Online Comment

Application H11-0095-25
Location Land off Cowper's Gate South Long Sutton Spalding PE12 9AY
Proposal Proposed Internal Access Road, HGV Trailer Parking Area, Surface Water Lagoon, Security Fencing and Landscaping

Name Gregor Robertson Morris
Address Lincolnshire County Council Lancaster House 36 Orchard Street LN1 1XX

Date Submitted 17-02-25
For/Against Comments

Proposed Site Plan

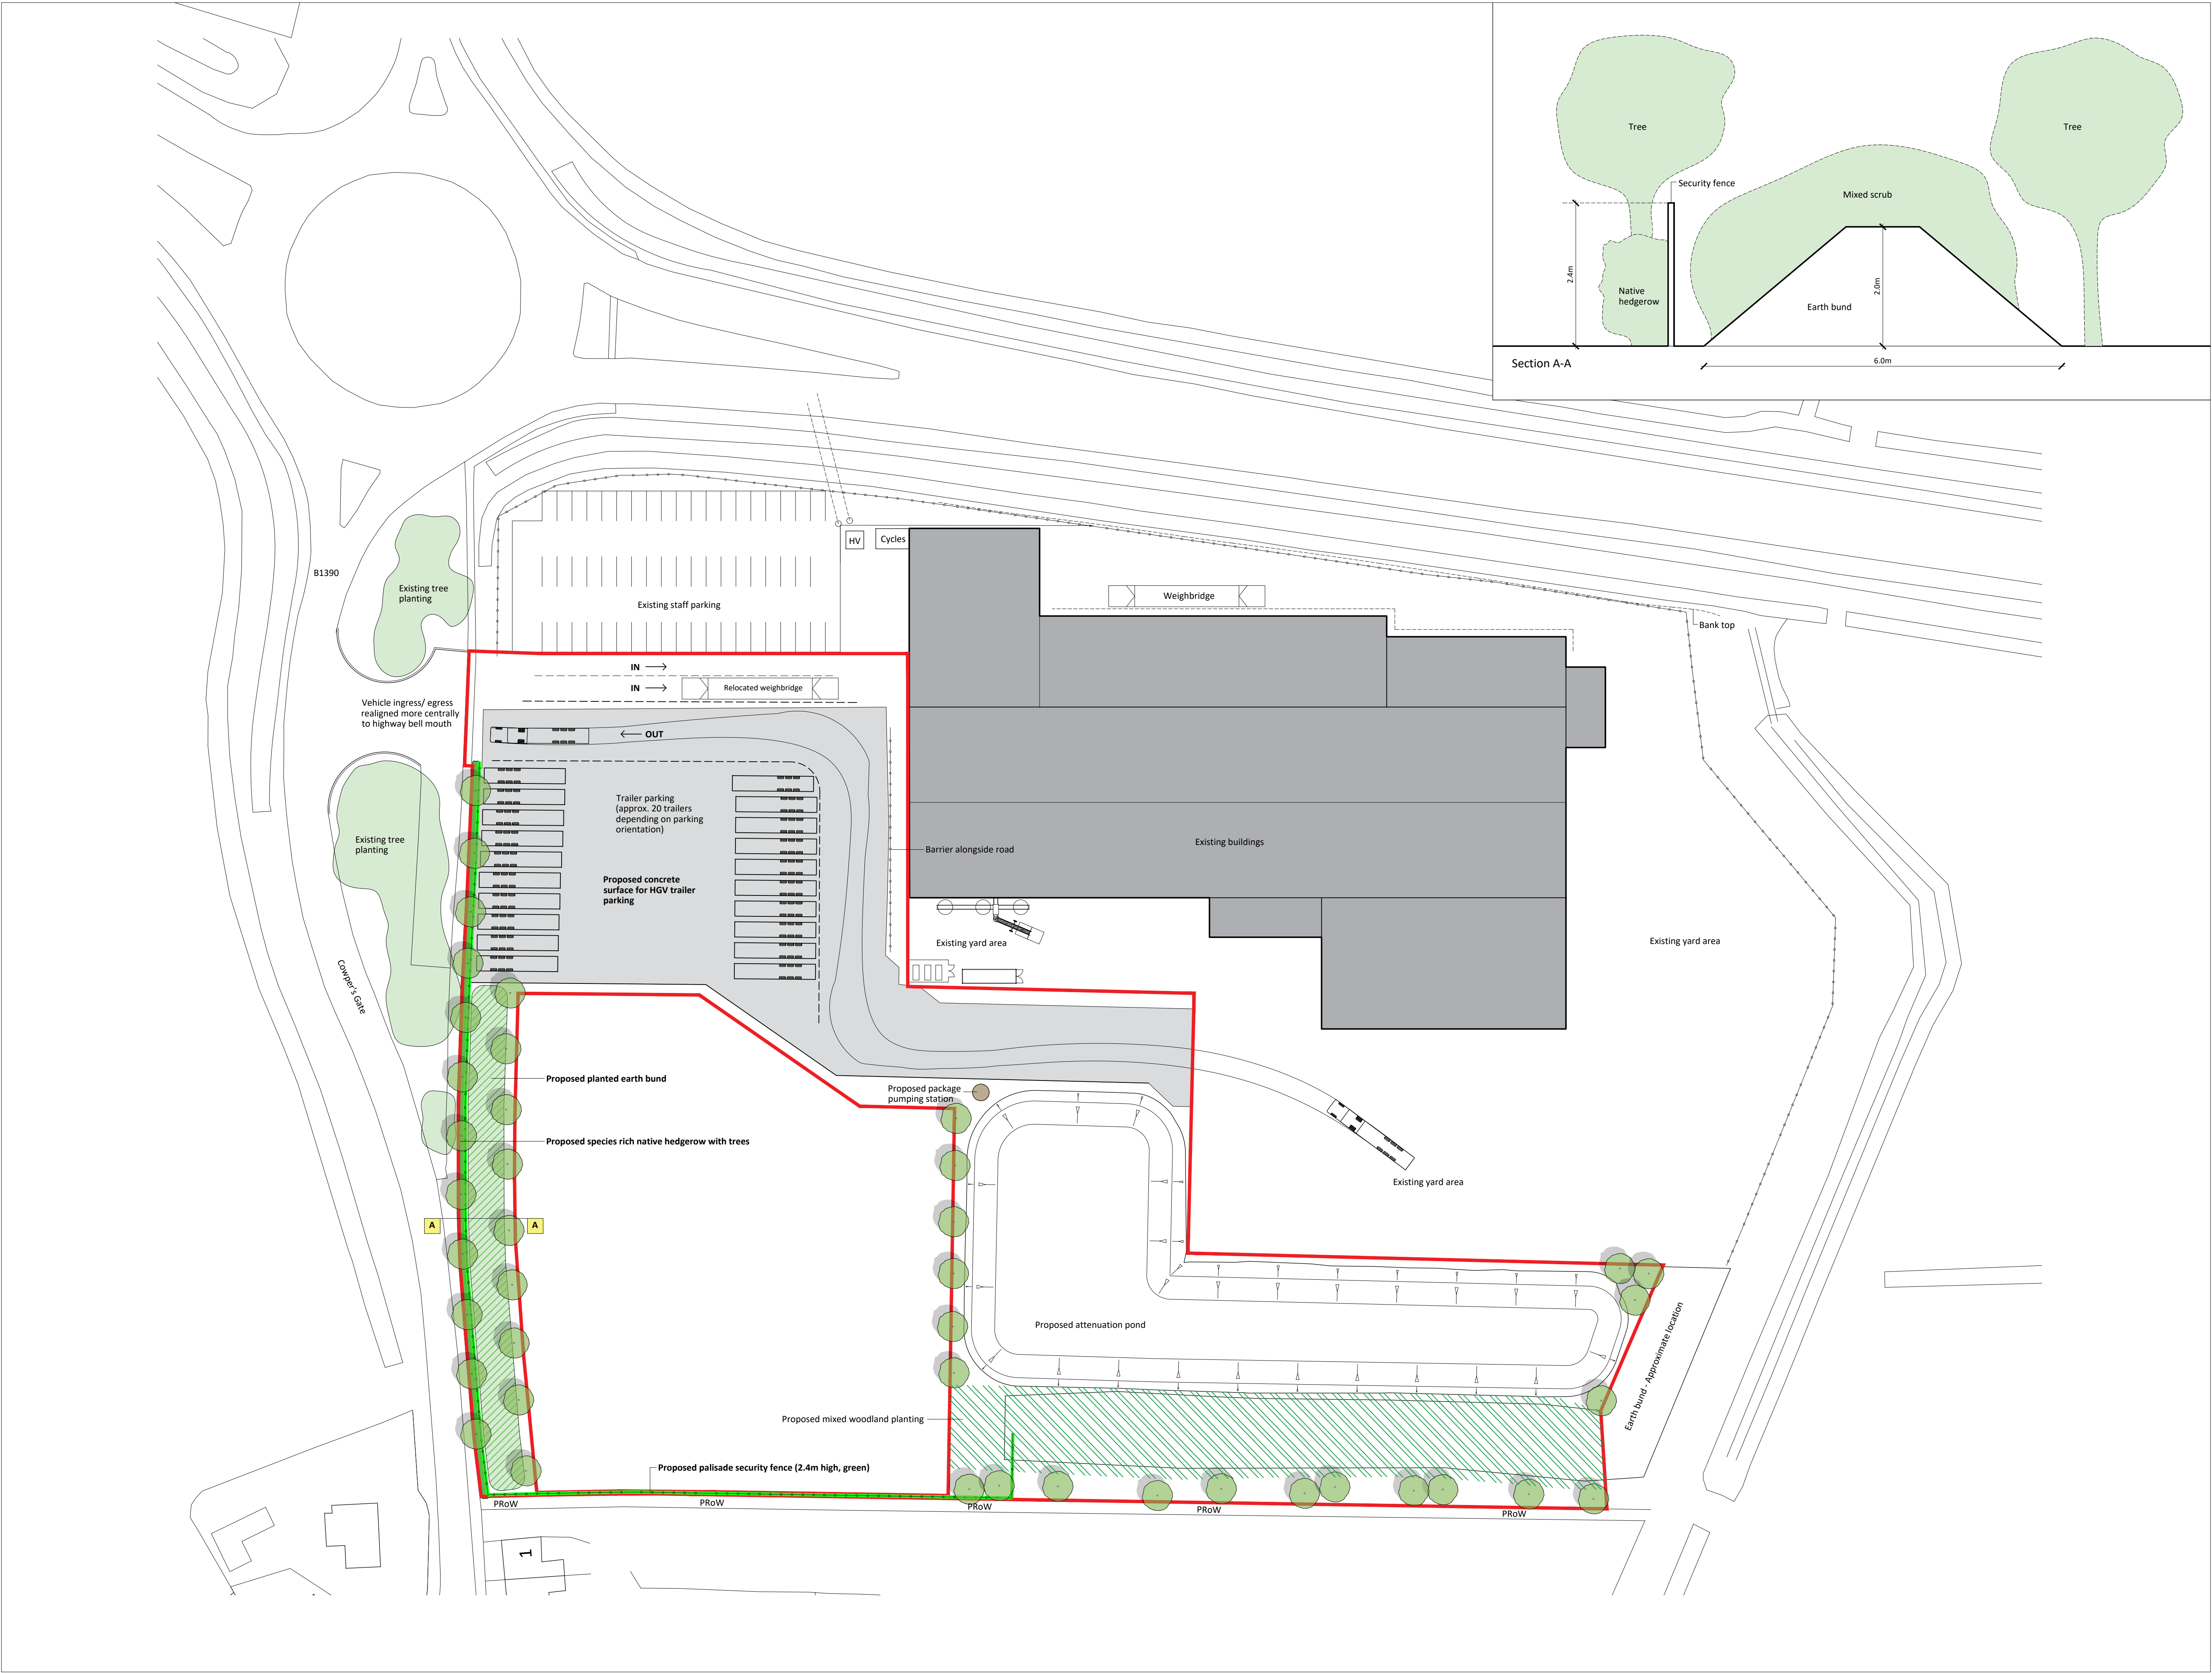
Paragraph 5.4 of the Design and Access Statement points to the fact that the location of the surface water lagoon has been changed from that proposed in application H11-1084-23 in order to avoid known archaeological remains. Archaeological evaluation in the form of geophysical survey and archaeological trial trenching was carried out in support of application H11-1084-23 and identified remains of medieval occupation in the western part of the site. It is probable that this extends north, towards the area of the proposed HGV trailer parking. While this area did have buildings associated with White House Farm constructed there, these did not cover the whole area and many of these dated to at least the 19th century when less intrusive foundations and construction processes were present. Therefore, there may have been limited impact on any potential below-ground archaeological remains.

The construction of the proposed HGV trailer parking and associated drainage, as well as any construction-related activities could have an impact on below-ground archaeological remains within and without the red-line boundary. The proposed earth bund could also have an impact on known below-ground archaeological remains due to physical compaction, changes to soil chemistry and hydrological changes.

Currently there is insufficient specific information on the archaeological potential for the northwestern area of the site and the extent of impact to buried archaeological remains from the proposed development. Therefore, I recommend that the applicant be required to provide the results of a trial trench evaluation which should aim to determine the presence, absence, significance, extent depth and character of any archaeological remains which could be impacted by the proposed development as noted above. This information should be provided with the application (prior to determination) so that an informed planning recommendation can be made and to meet the requirements of the National Planning Policy Framework (NPPF) 2024 (paragraphs 207 & 218).
